Response to Planning Application

From: Arun District Council Greenspace

Application ref: F/4/20/OUT

Location: Land at Ford Airfield Ford, West Sussex

Figure 124: Open Space Typology

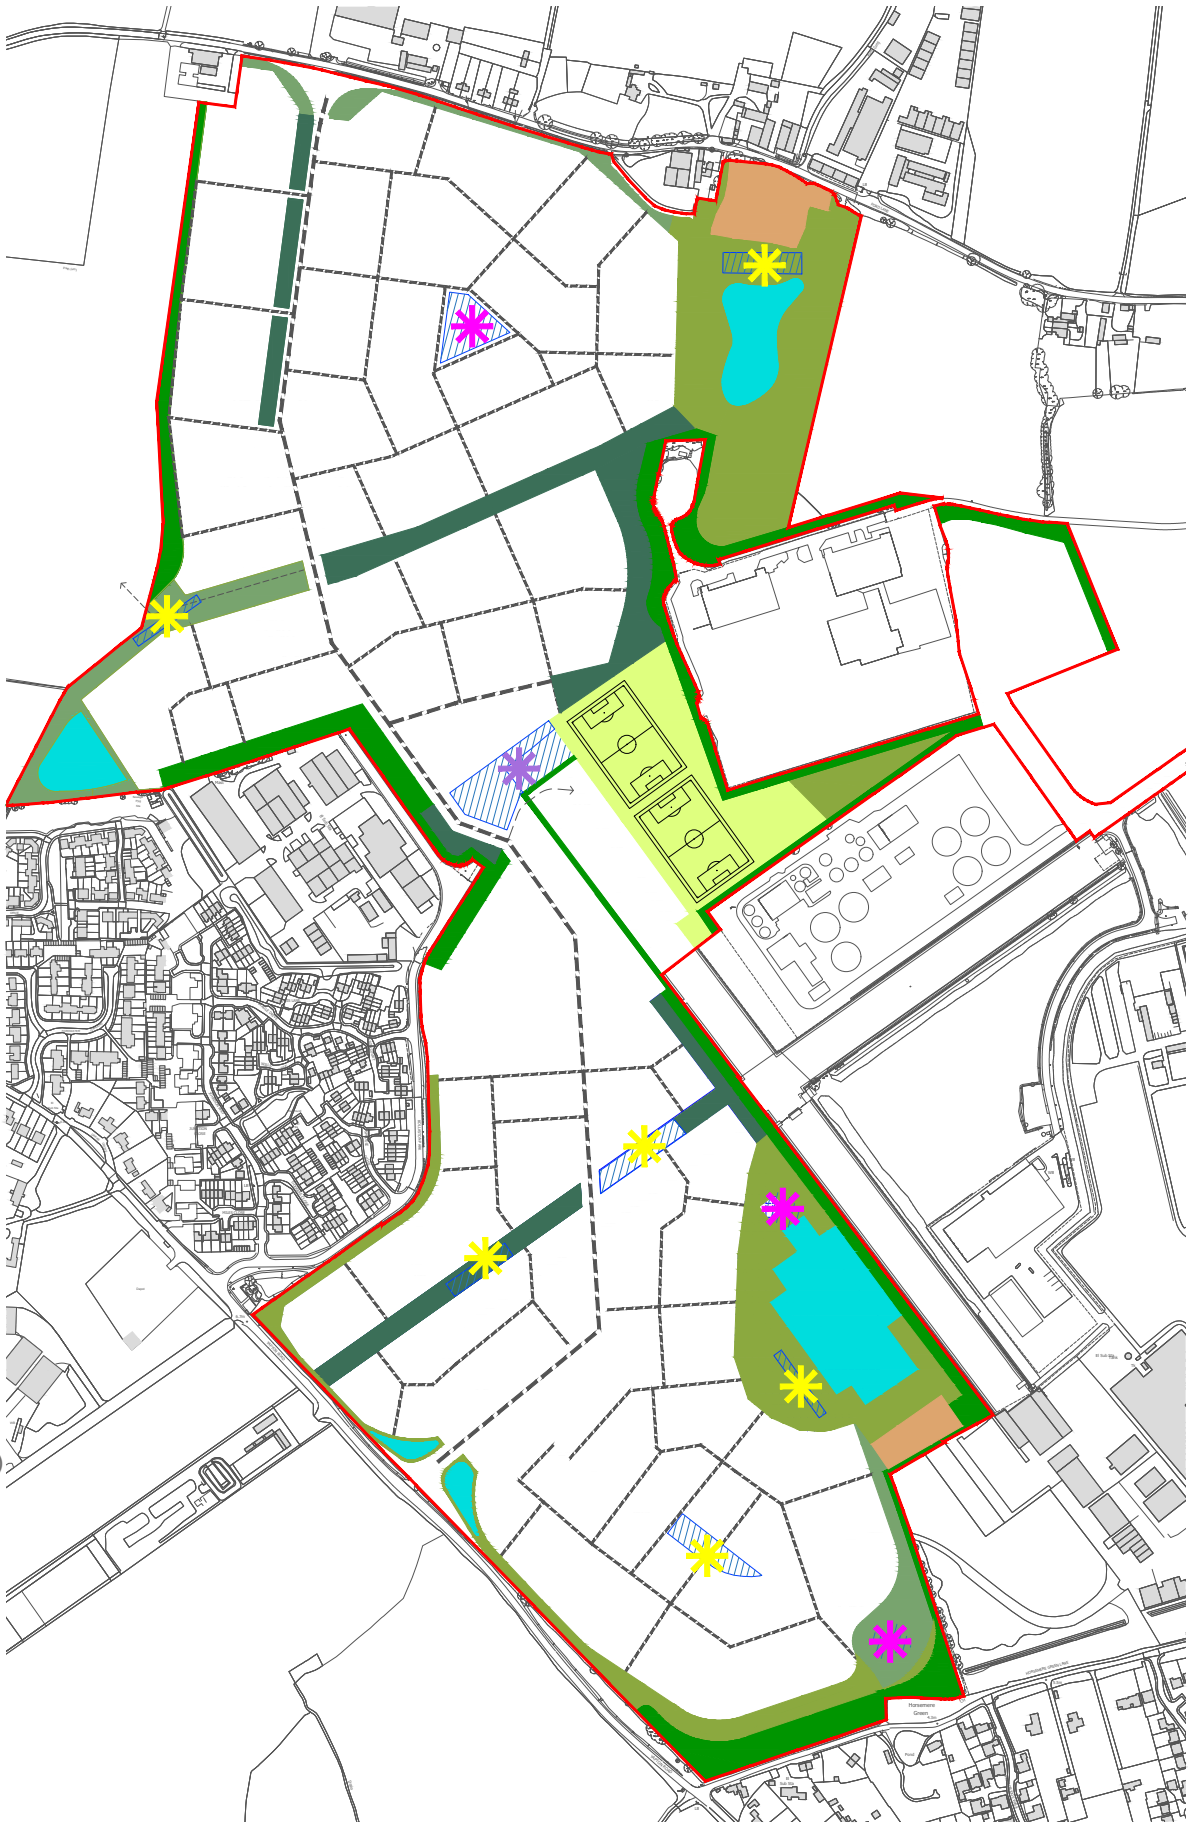
There will be the requirement for standards of greenspace and leisure provision as set out in Arun District Councils SPD - Open Spaces, Playing Pitches, Indoor and Built Sports Facilities; January 2020 This provision will need to include at least minimum standard calculated POS areas (12.38 ha) multiple LAP, LEAP, NEAP, MUGA, allotment, sports pitches and ancillary facilities along with a robust and enhancing landscape scheme across the site.

FIGURE 5. ILLUSTRATIVE MASTERPLAN

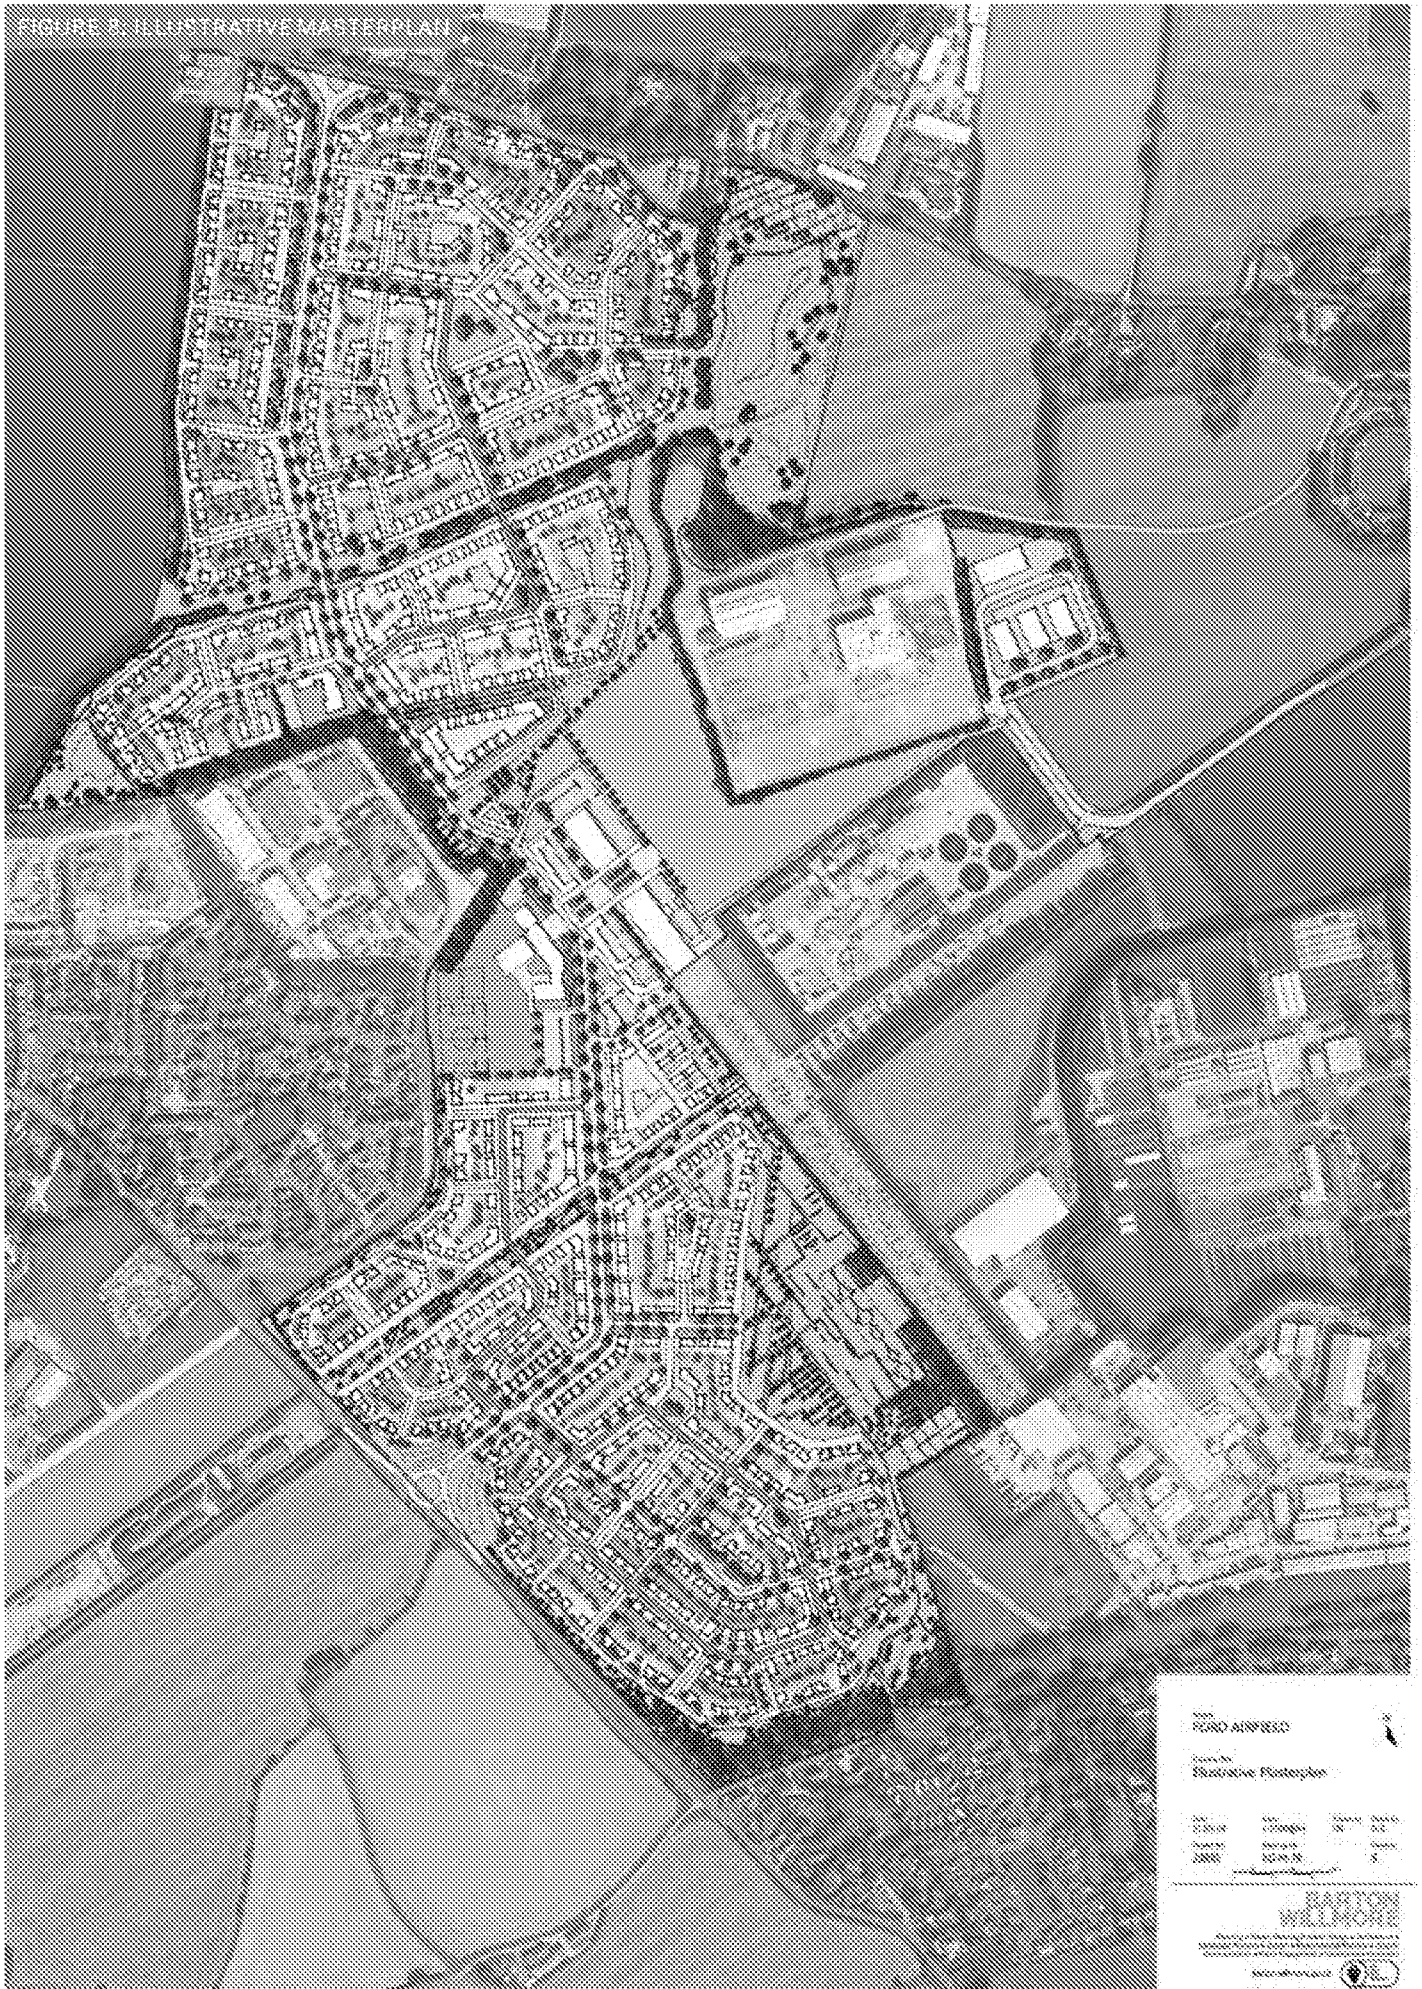
The illustrative masterplan 78s has indicated the retention of existing sports facilities and the provision of land of 3.23Ha sufficient to accommodate 2 full size adult football pitches. Further consultation will be required regarding this proposed provision and further for related changing facilities and associated carparking considerations.

Shown allotment provision will also require accessibility by car users and associated parking for these.
